**ADC Planning Consultation
Response from the Conservation Officer**

Application Number	AB/65/14/L
Address	Troy House East 83 Tarrant Street Arundel BN18 9DN
Description	Application for Listed Building Consent to paint rear elevation
Case Officer	Mrs A Gardner

# ELEVATIONS WITH PHOTOGRAPH

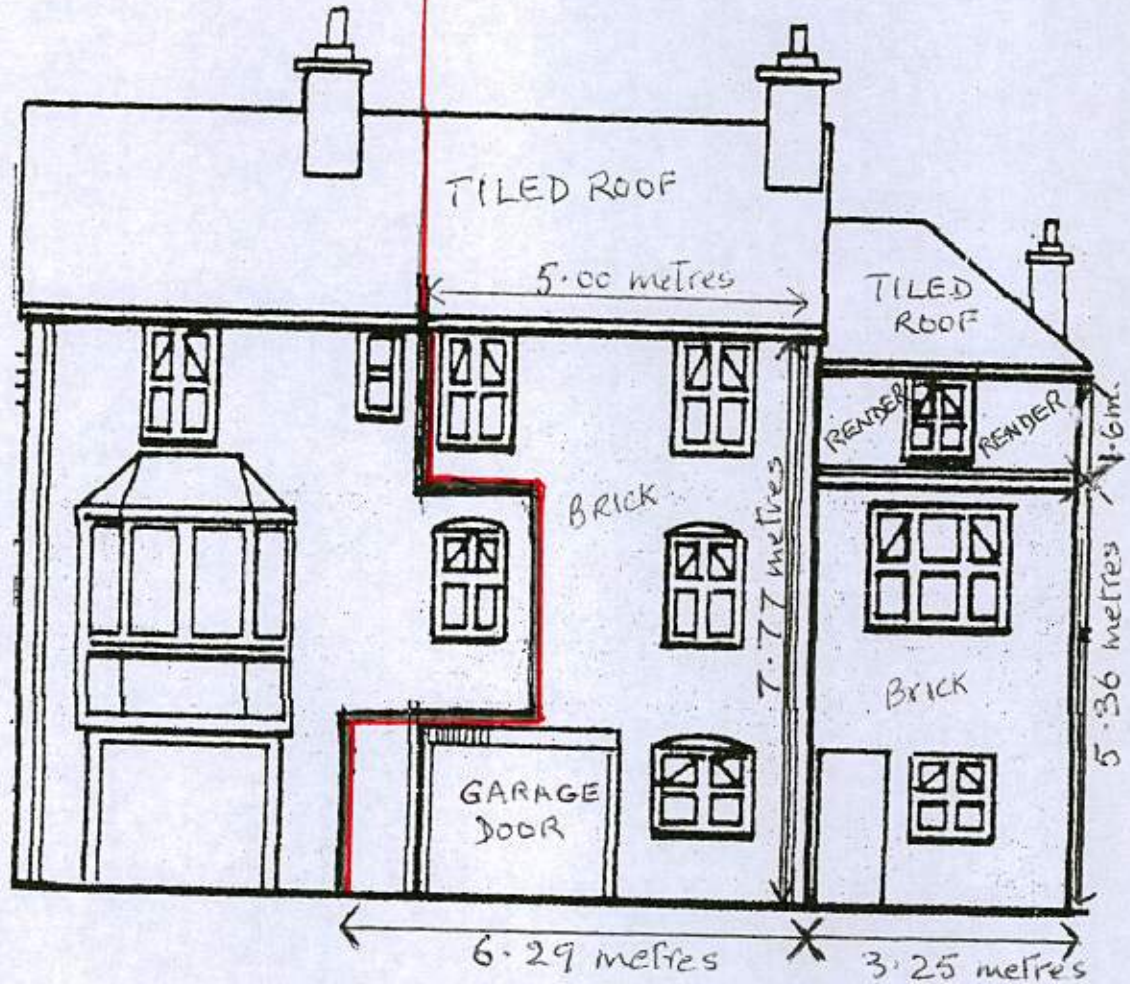
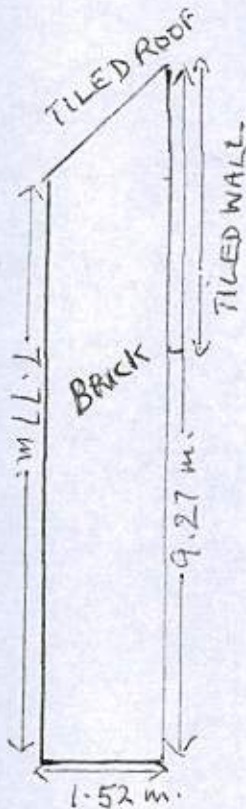
The application is to paint the rear elevation of the property. It should be noted that it is preferable to use an 'off white' colour in the historic environment, as opposed to a stark white. However, in this circumstance, it is considered that the proposal will not harm the character or appearance of the conservation area.
